CITY OF ALBUQUERQUE

Re: Lupe's Cafe
1524 Central Ave. SE
Traffic Circulation Layout
Architect's Stamp 06-03-22 (K15-D102)

Based upon the information provided in your submittal received 08-19-22, the above referenced plan cannot be approved for Building Permit until the following comments are addressed:

SHEET
TCL

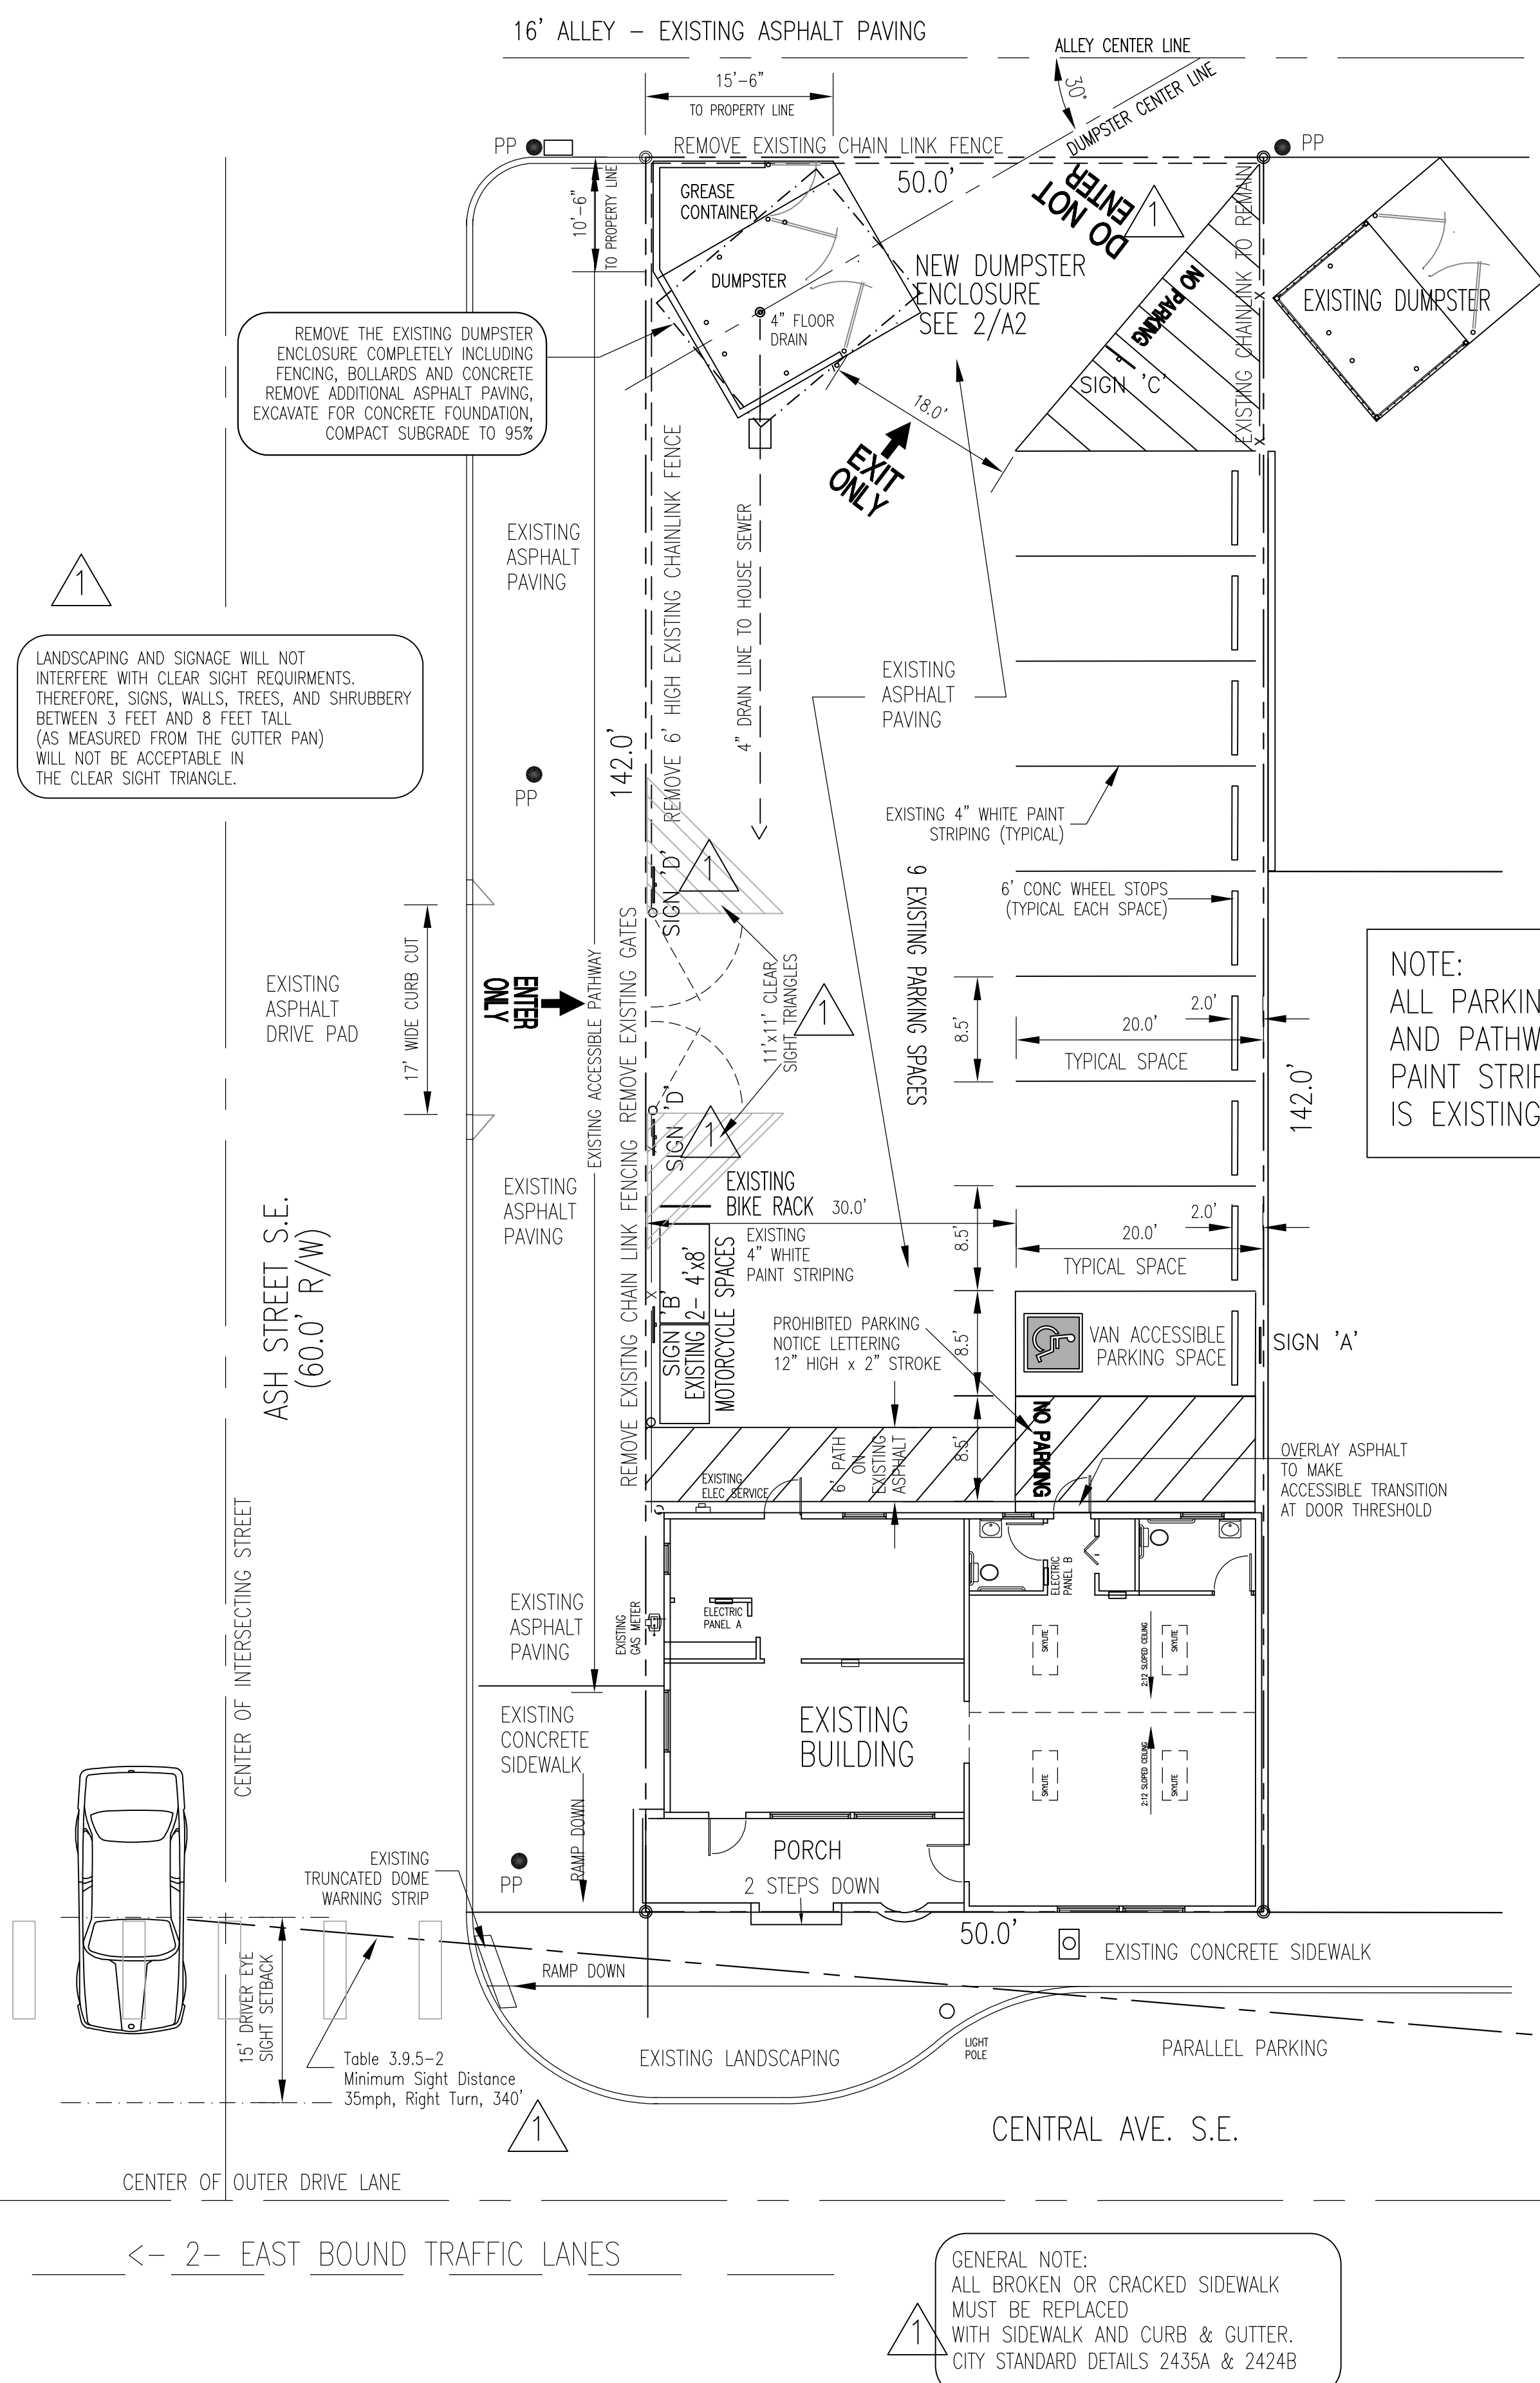
1. Motorcycle parking spaces shall be designated by its own conspicuously posted upright sign, either free-standing or wall mounted per the zoning code.

2. The pavement marking "MC" should be shown in the opposite direction for motorcycles entering the parking space.
3. All one-way drives shall have "One Way" and "Do Not Enter" signage and pavement markings. Please show detail and location of posted signs and striping.

4. Please provide a sight distance exhibit
5. Show the clear sight triangle and add the following note to the plan: "Landscaping and signage will not interfere with clear sight requirements. Therefore, signs, walls, trees, and shrubbery between 3 and 8 feet tall (as measured from the gutter pan) will not be acceptable in the clear sight triangle.

6. Add a note stating "All broken or cracked sidewalk must be replaced with sidewalk and curb & gutter." A build note must be provided referring to the appropriate City Standard drawing.
